Response to Examiners Questions.

by Richard Gregory.

Geology of Site G.

Title:
Figure 8.1.5 Site Locations and Study Area
Green Hill G

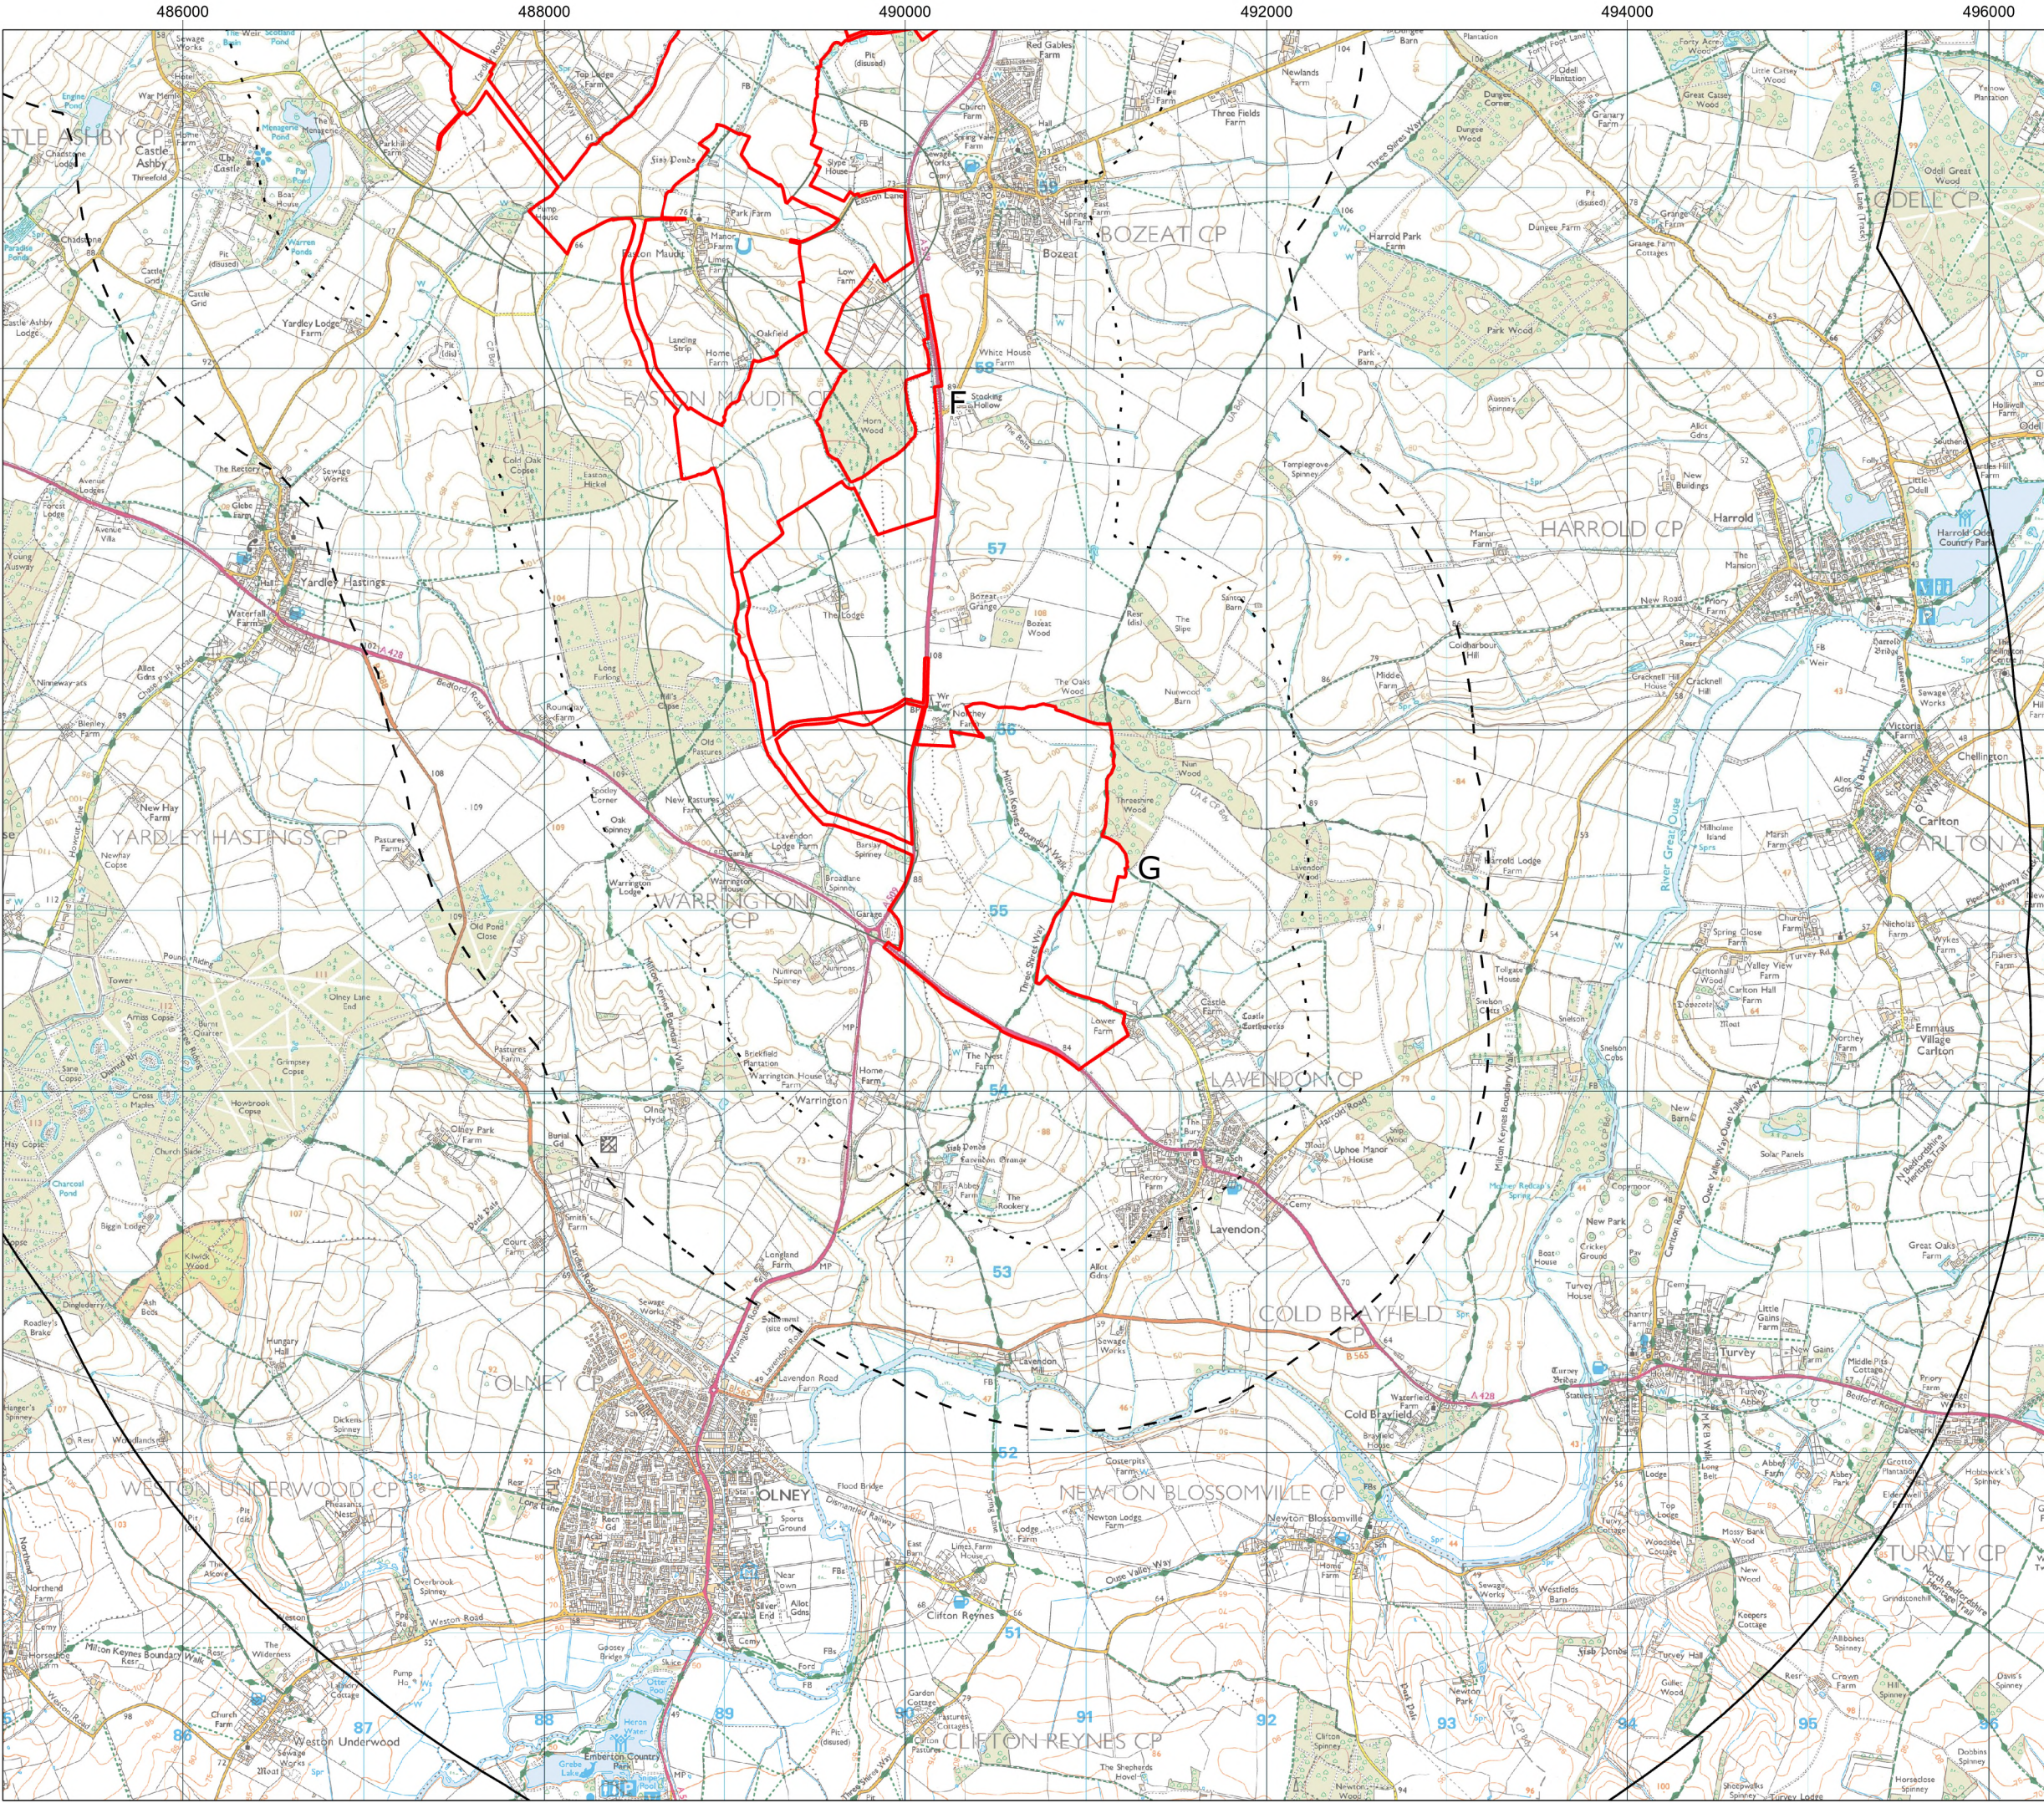
Question - A submission at page 18 of your written representation at Deadline 1 [REP 1-283 ] challenges statements in the EIA Scoping Report [APP-066 ] concerning the geology of Site G. How, if at all, do you consider that the two photographs affect the assessment of flood risk to and from Site G of the proposed development.

The two photographs show the excavation operations to build an equestrian menage at Lower Farm in 2017. The excavator had to dig through the clay top soil and limestone bed rock and encountered blue clay at a depth of approx 1.5metres. to establish a level platform. The menage is located 2 metres South of the drainage channel and only 50 metres to the East of the Site G boundary.

The ground conditions of Site G so close to these excavations must be similar although although the the depths at which the blue clay pockets are exposed may vary. These photographs visually demonstrate the lack of permeability of the ground conditions in this area. From past experience we know that during heavy rain storms the surface water run-off from both our fields and Site G quickly fills up the drainage channel but the levels also drop when the rain stops which reflect the fact that the clayey topsoil is not absorbing the water.
